Application number: 2021/94744	
What is the application for?:	Demolition of detached garage and erection of front porch, two storey side, and
Address of the site or building:	23, New Hey Road, Marsh, Huddersfield, HD3 4AL
Postcode:	HD3 4AL

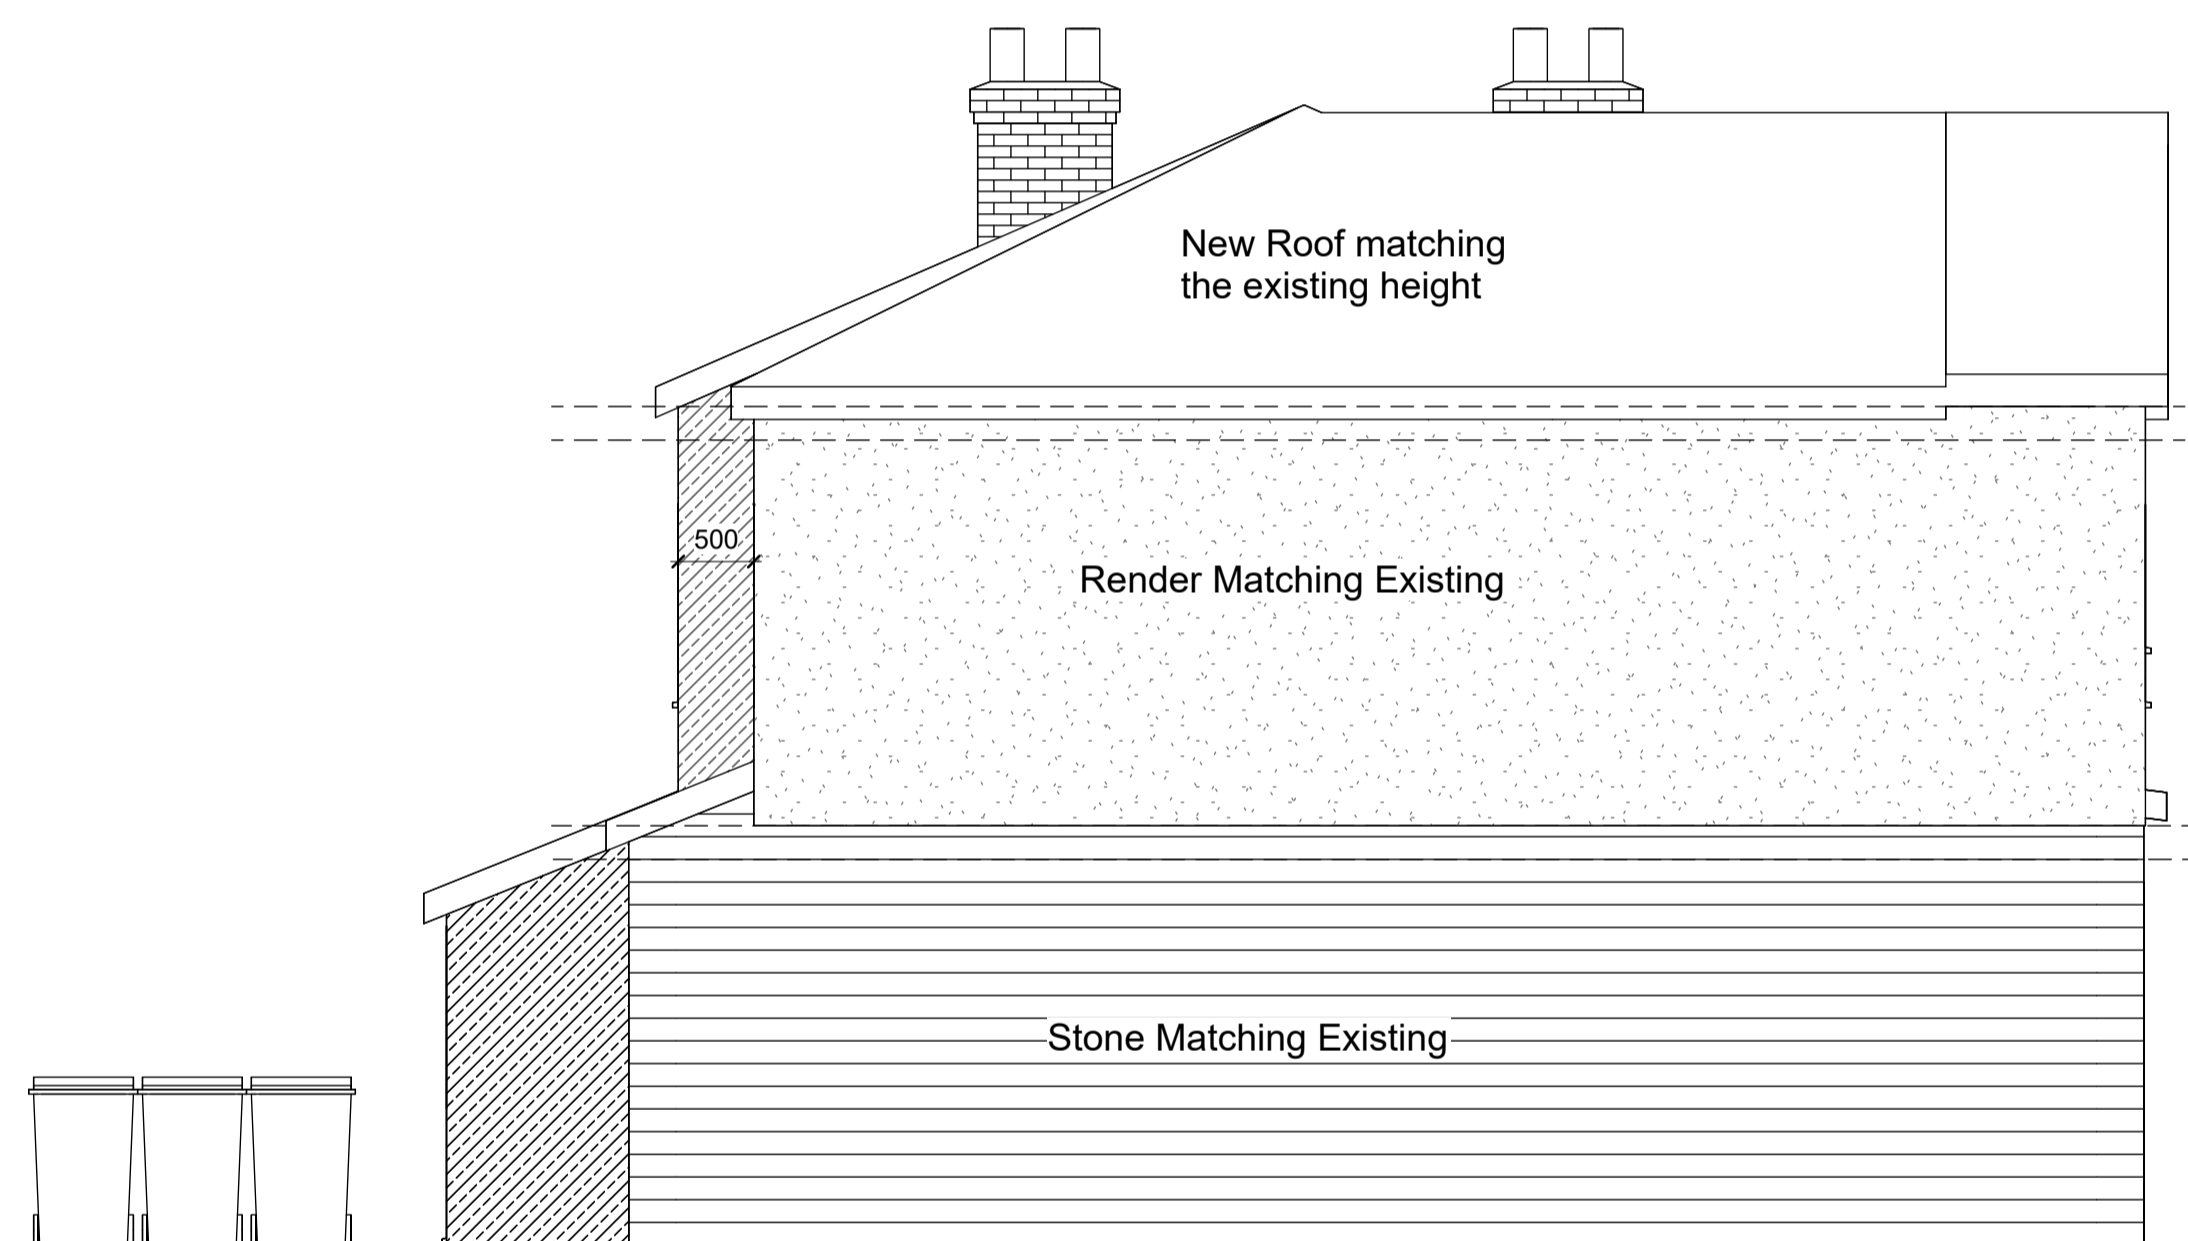
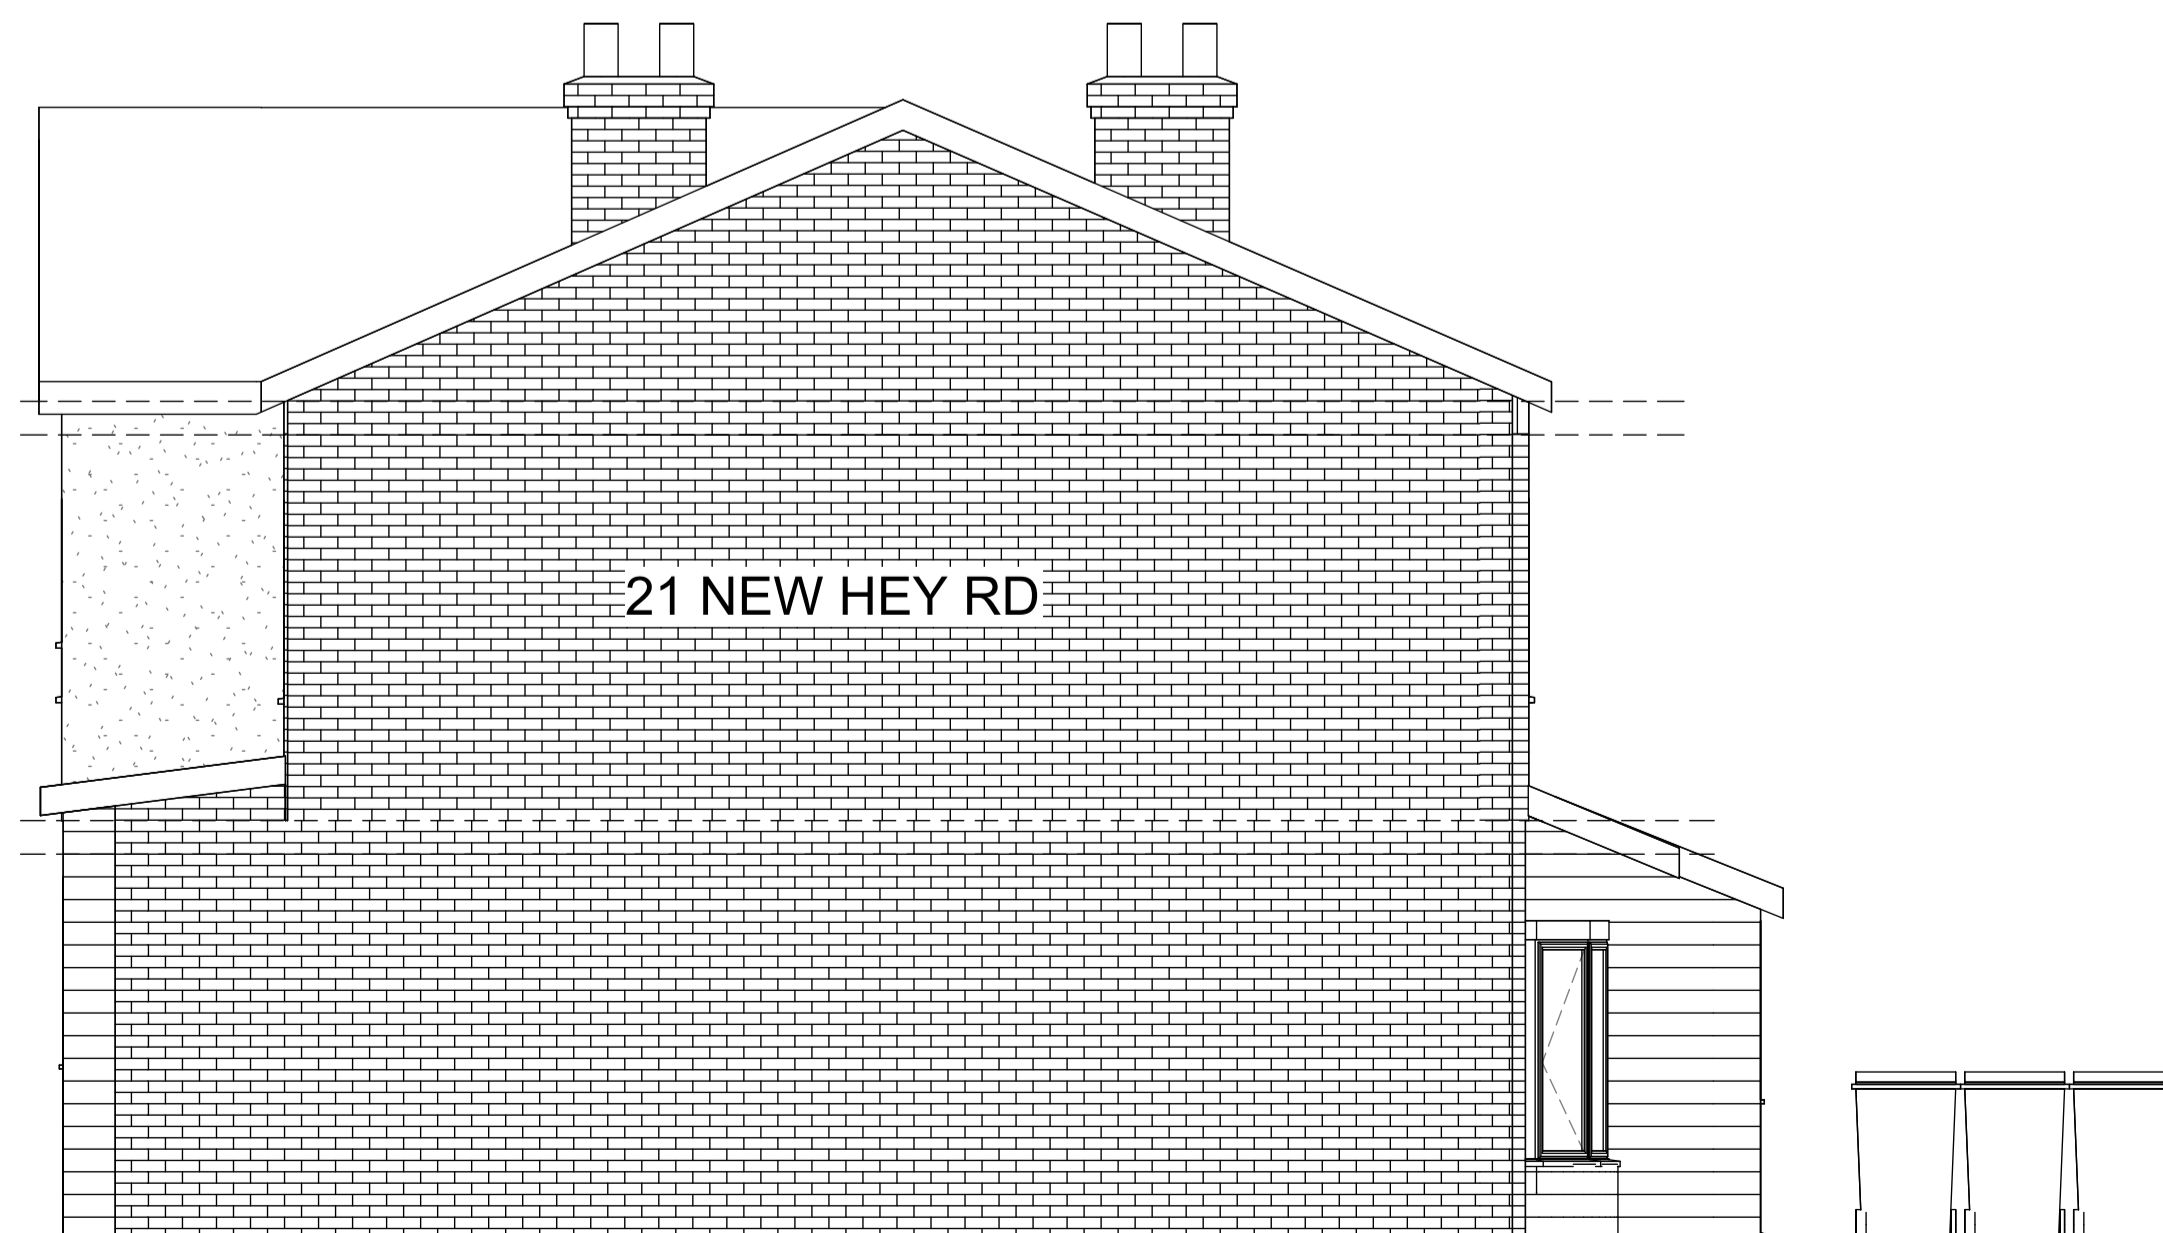
Type of comment: An objection	
Do you wish your comments to be published on the website anonymously?	No
the plans for the extension to the side of the property make it clear that the wall of the extended property comes up to the boarder of my property. Which means that the roof (including the eaves and the guttering will overhang my boundary line.
